Our Ref: BR/262/19/HH
Your Ref:

Town & Country Planning Act 1990 (as amended)
Town & Country Planning (Development Management Procedure) (England) Order 2015
Application for Planning Permission for Works or Extension to a Dwelling

Development Pavement Crossing and dropped Kerb
Location 181 Chichester Road Bognor Regis

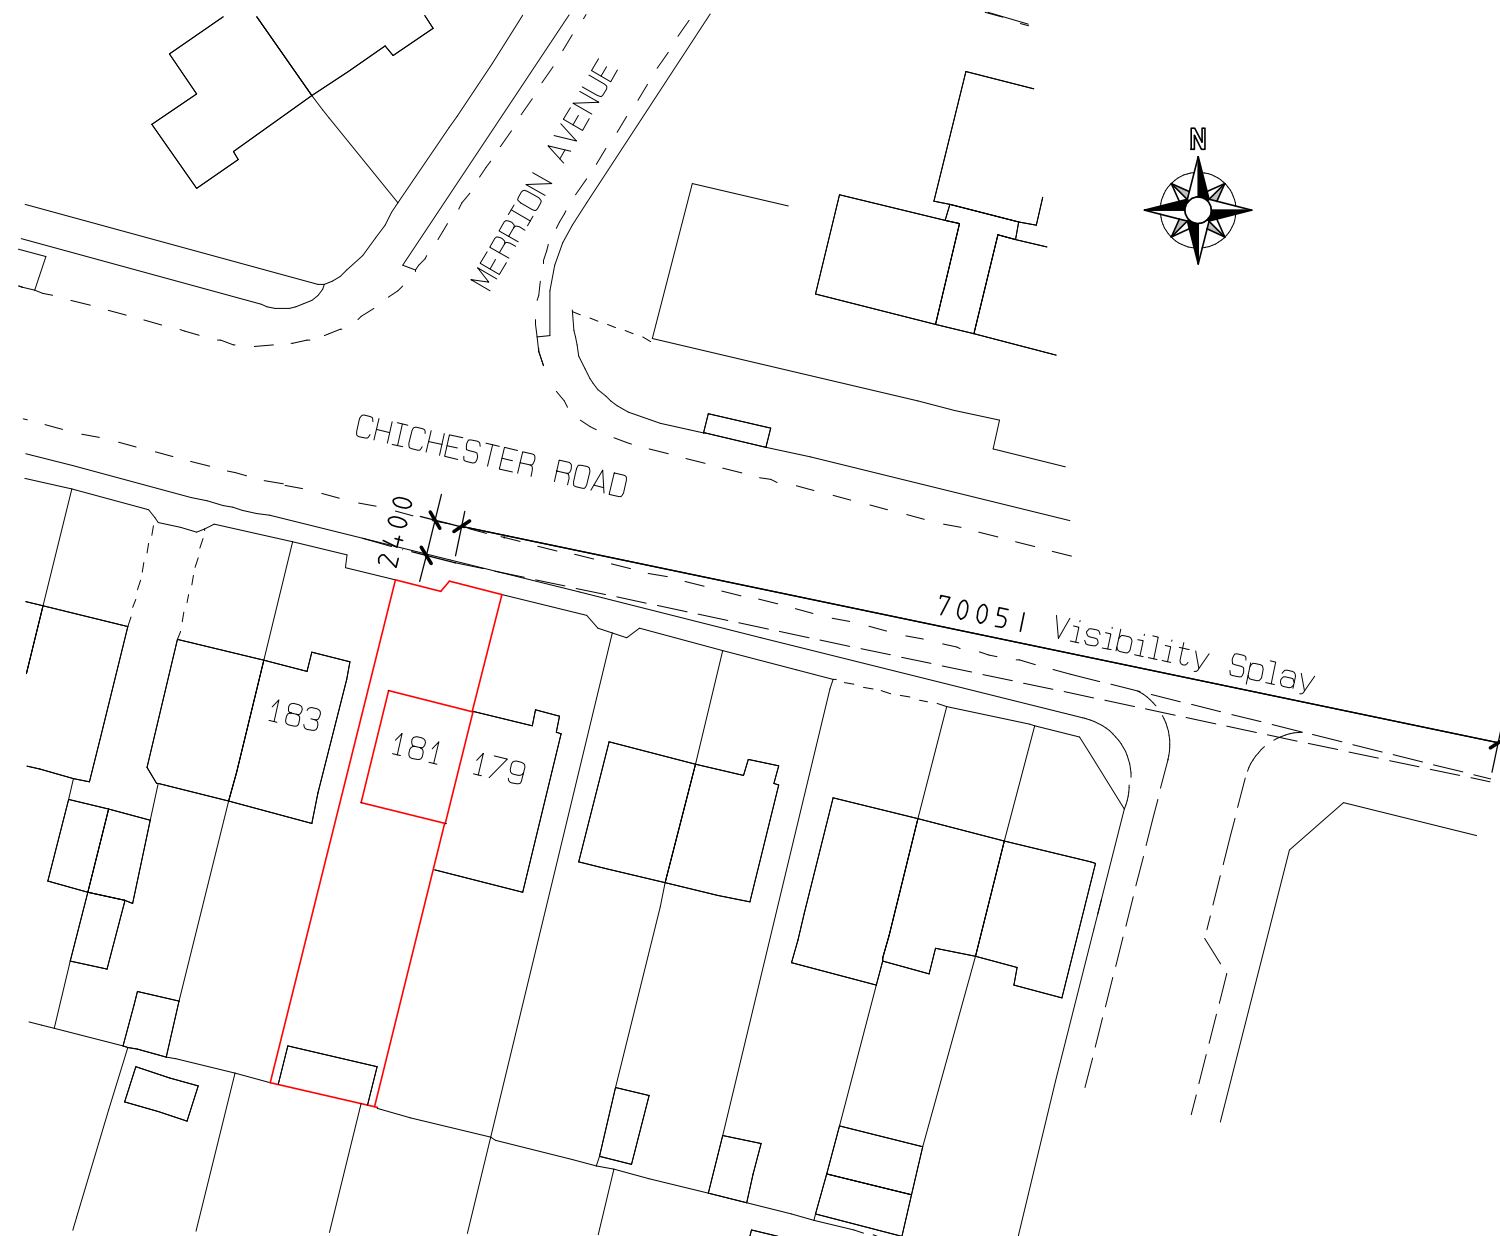
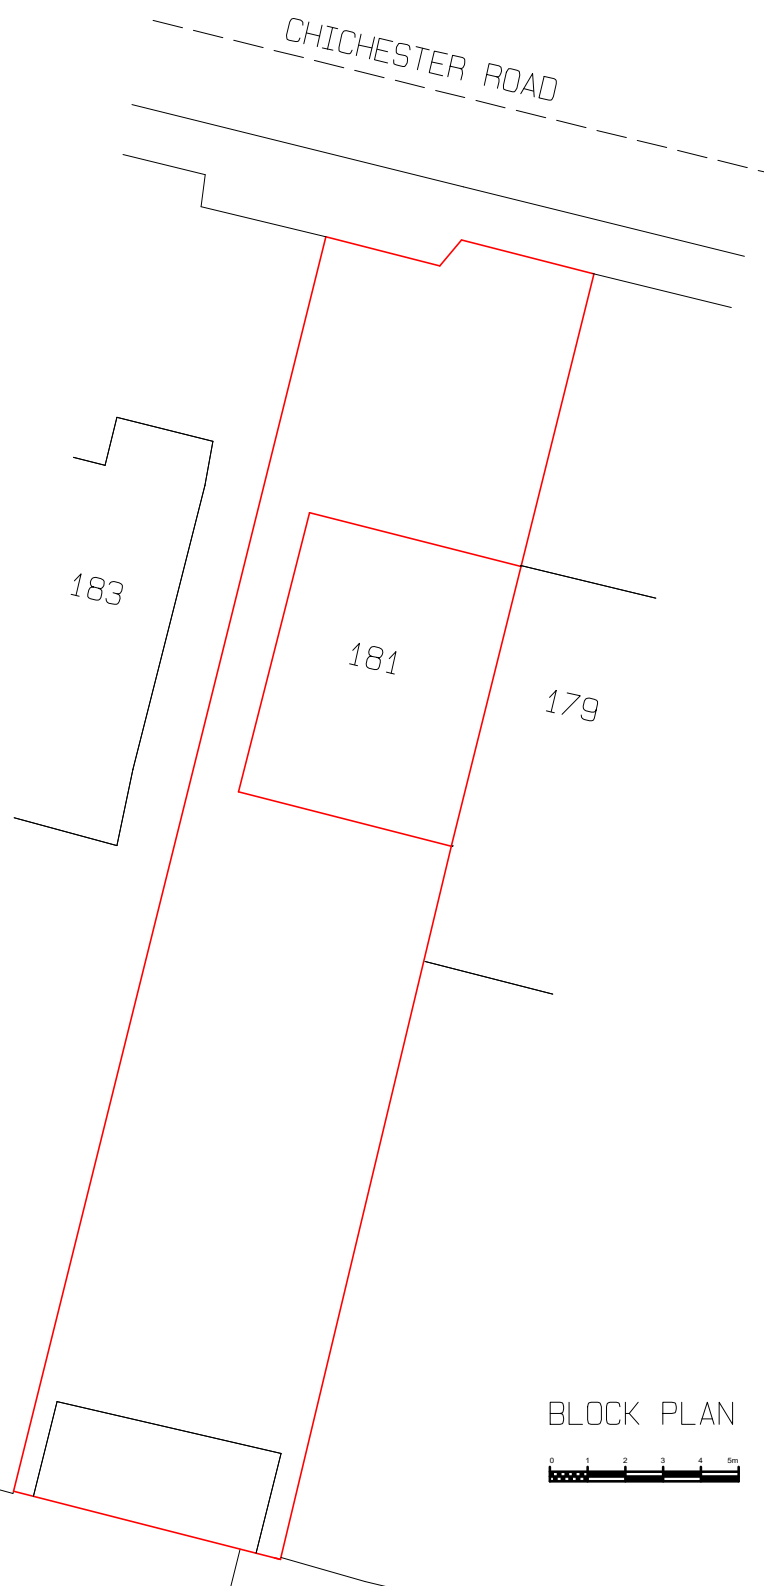
Splay Plan Required: A visibility splay is formed by measuring to a point 2.4m back from the carriageway in the centre of the driveway or entrance. A line (70m long in the case of a 30mph limit) is then drawn to the right, to a point where it strikes the near-side edge of the carriageway.
